Re: | Cobborra Coal Project - responses to noise queries

Responses to the Department of Planning and Infrastructure (DP&I) questions since completion of the Planning Assessment Commission (PAC) Review Report for the Cobborra Coal Project (the Project) are attached.

Year 8 Prevailing wind meteorological conditions (extraction only)

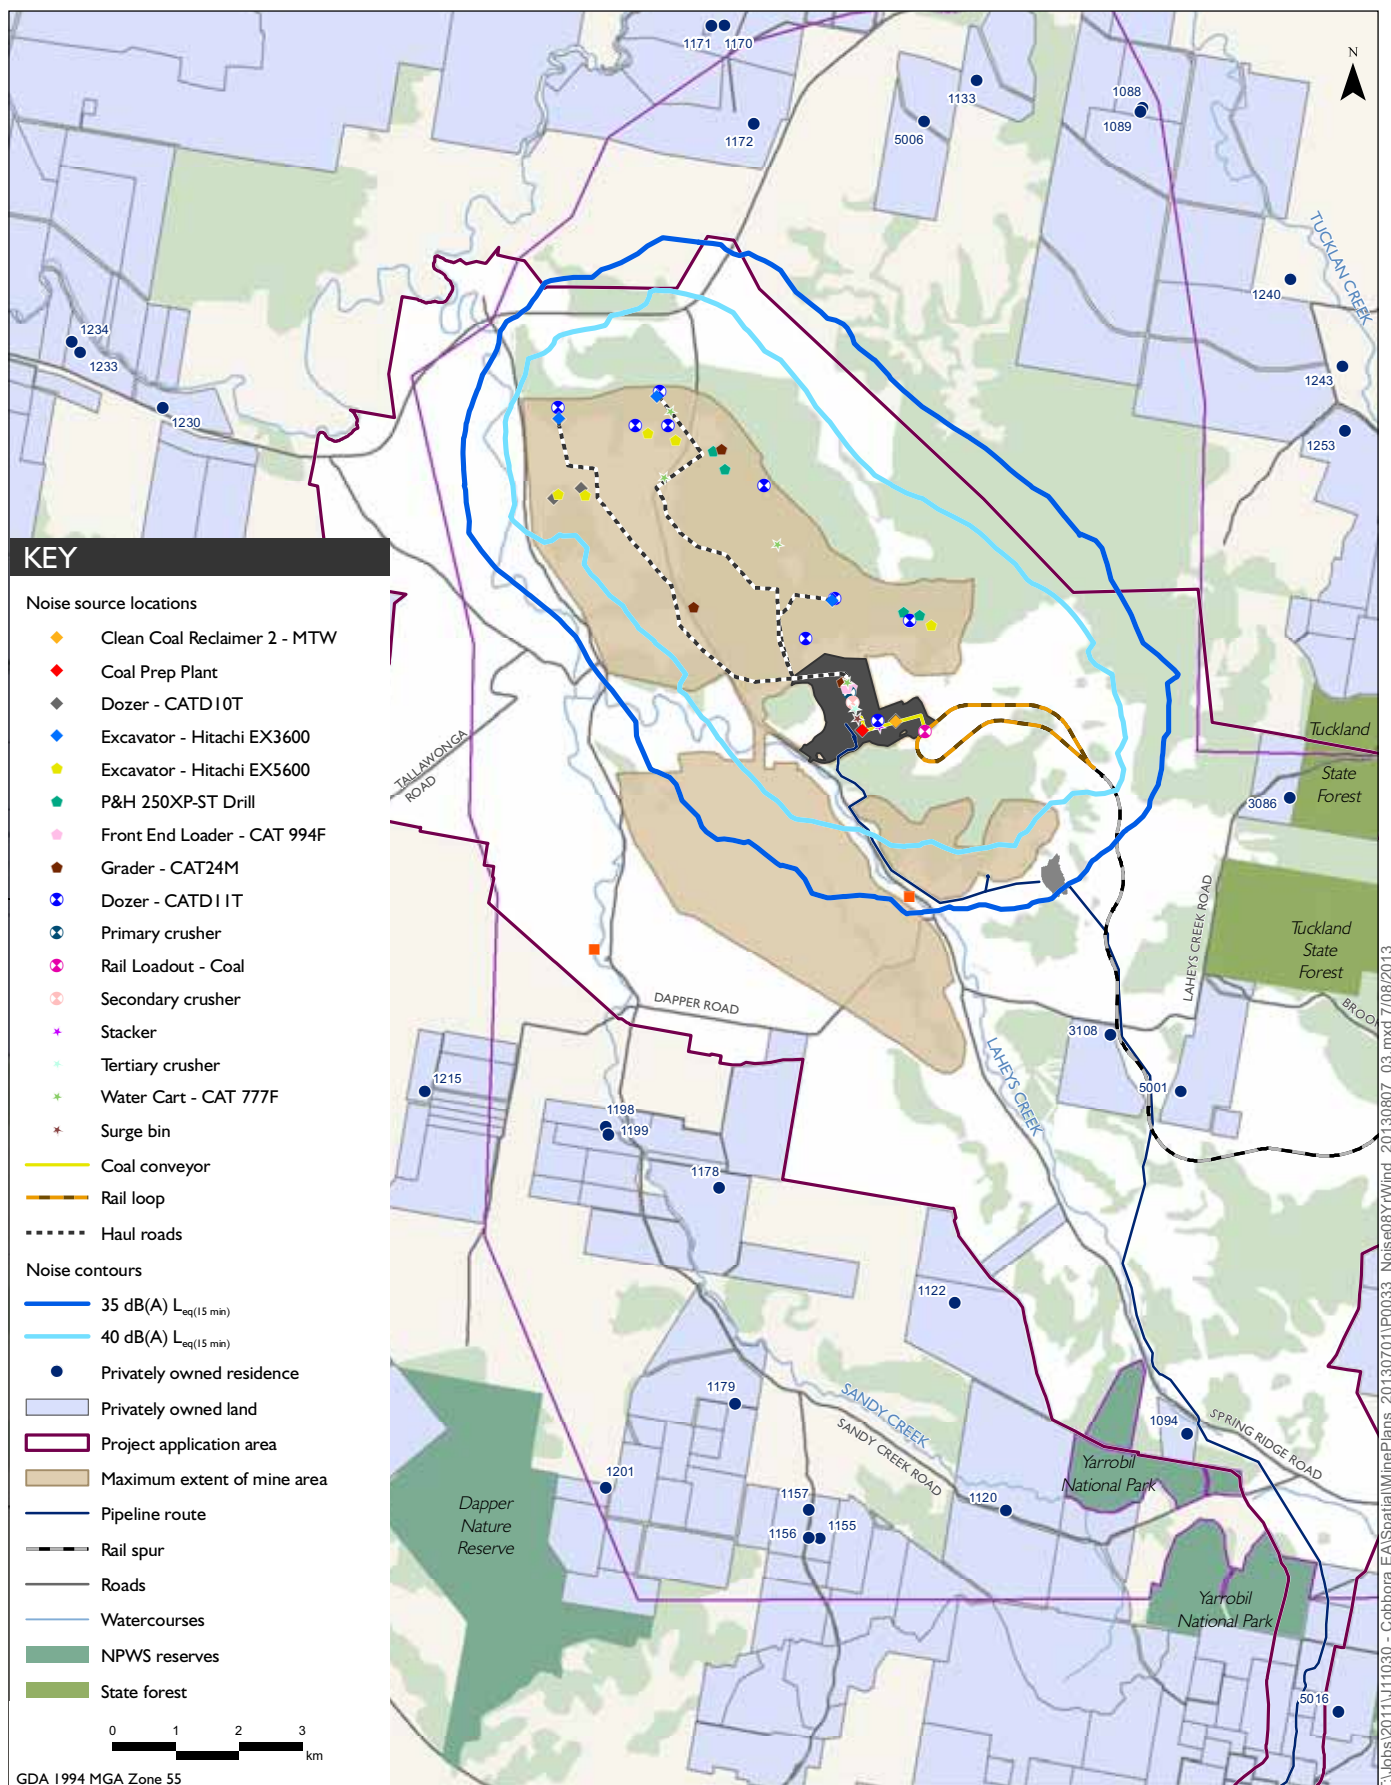
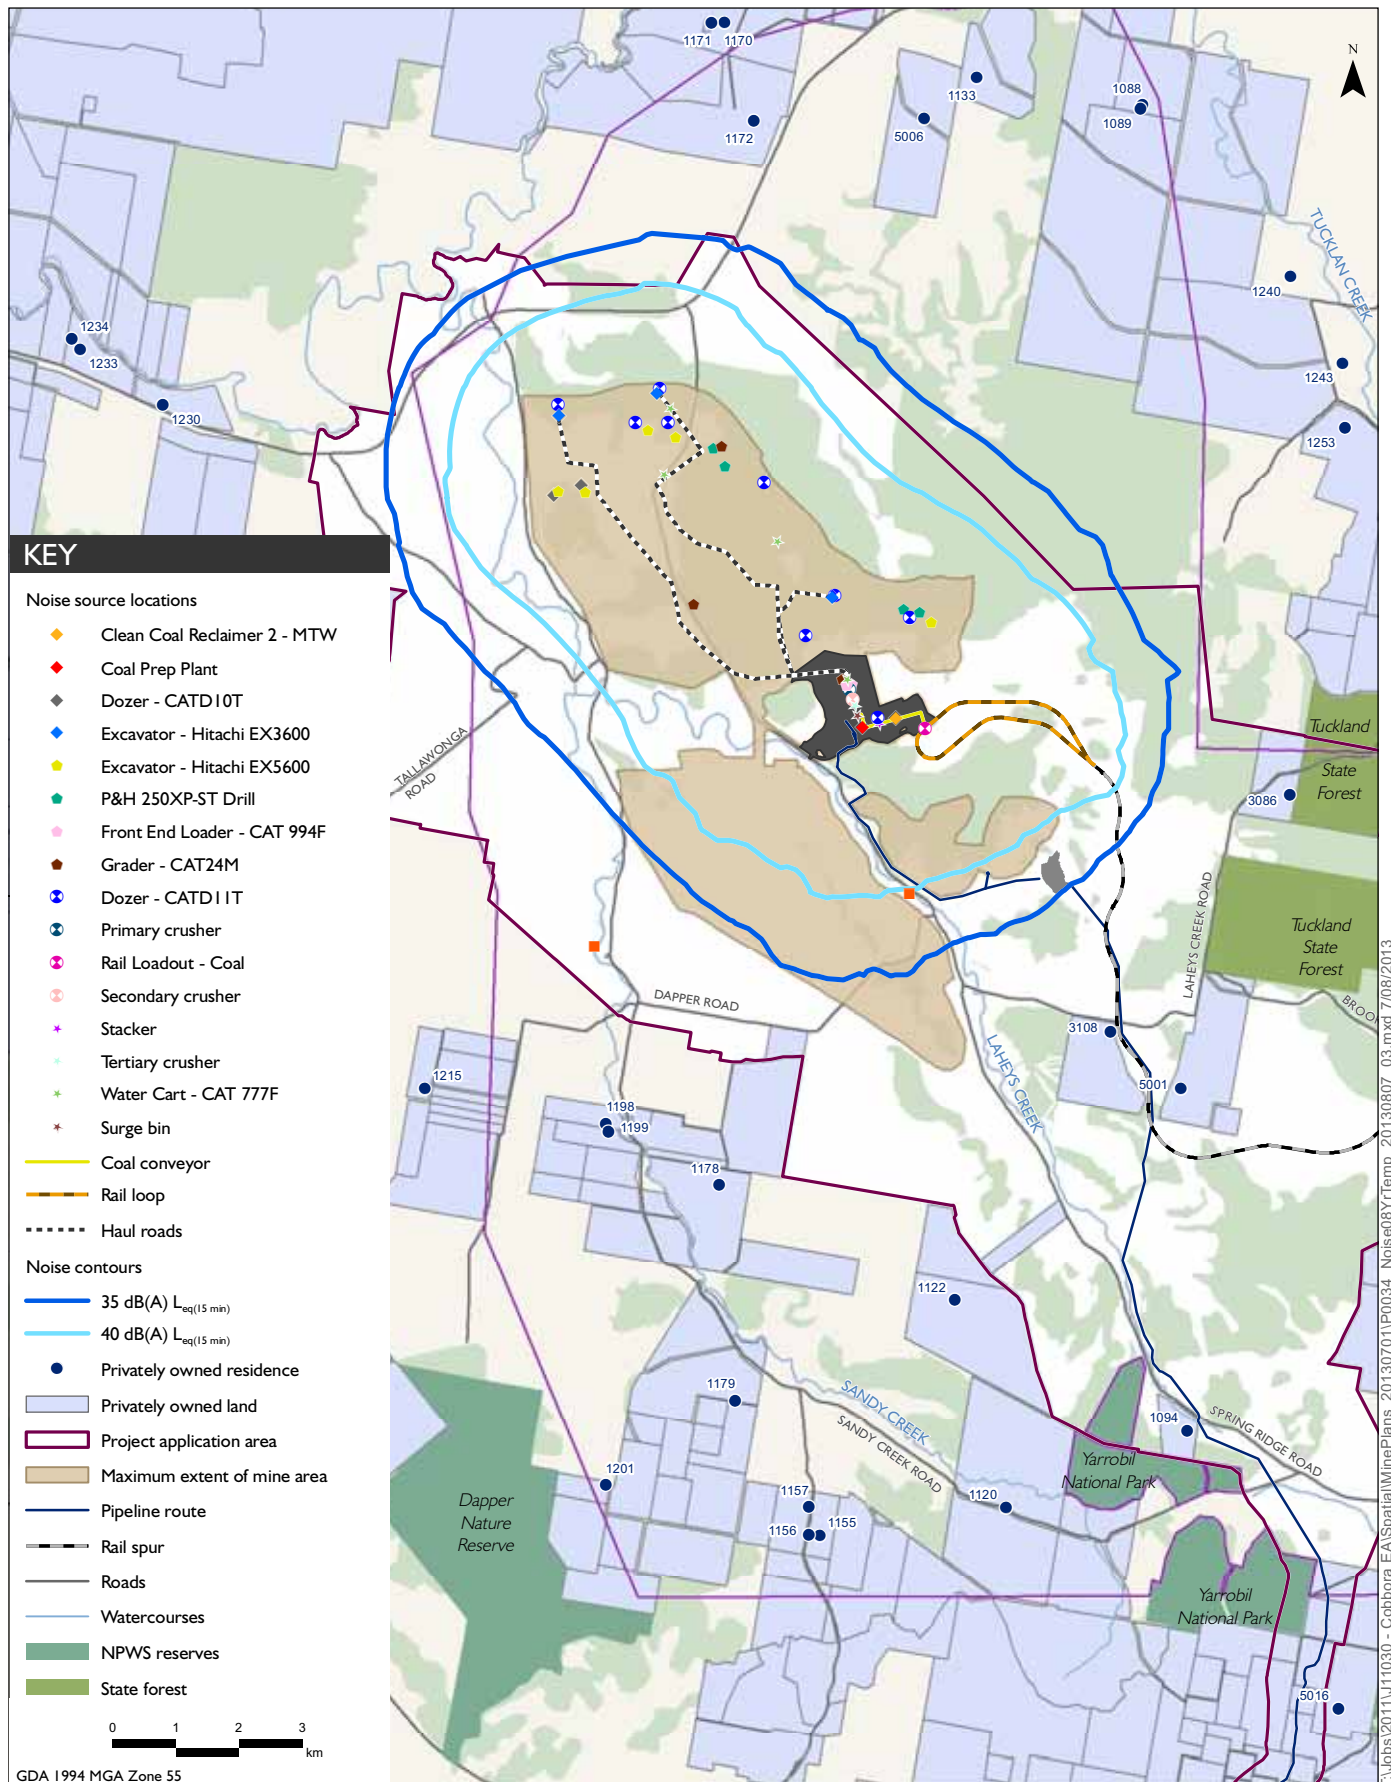
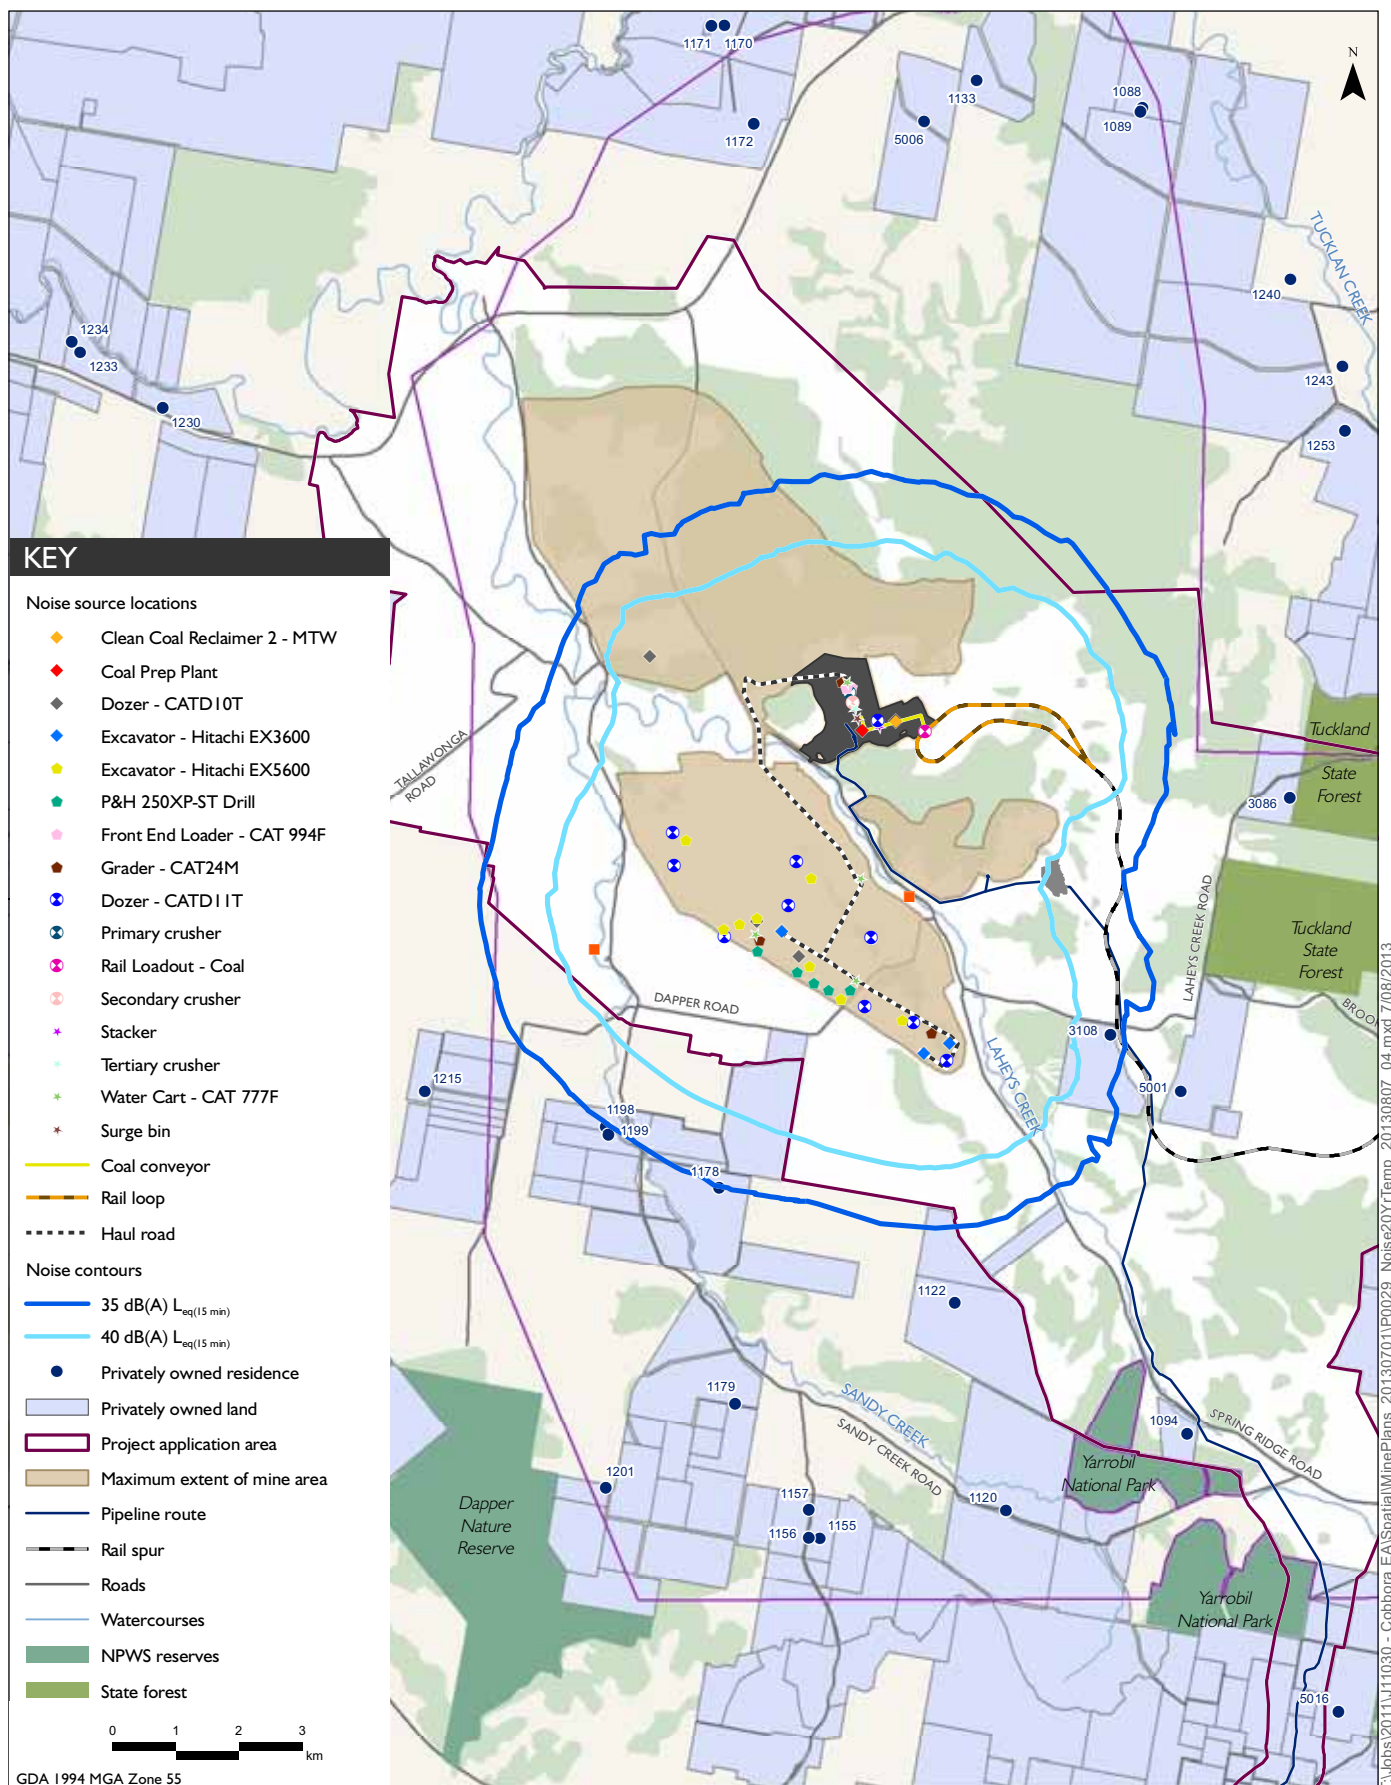
Is it possible to provide a noise contour map (with 35 and 40dB contour) for the year 20 operations maximum impact adverse meteorological scenario for extraction only - that is not combined extraction and rail. This will be useful for the assessment report in clearly showing impacts from mining operations alone without rail spur line contribution.

See Section 3.2 of Appendix I of the *Cobbora Coal Project Response to Recommendations of the Planning Assessment Commission Review Incorporating a Revised Preferred Project Report* (EMM, 13 May 2013) (the PAC Review Report) for extraction-only noise contours for Year 8 and Year 20.
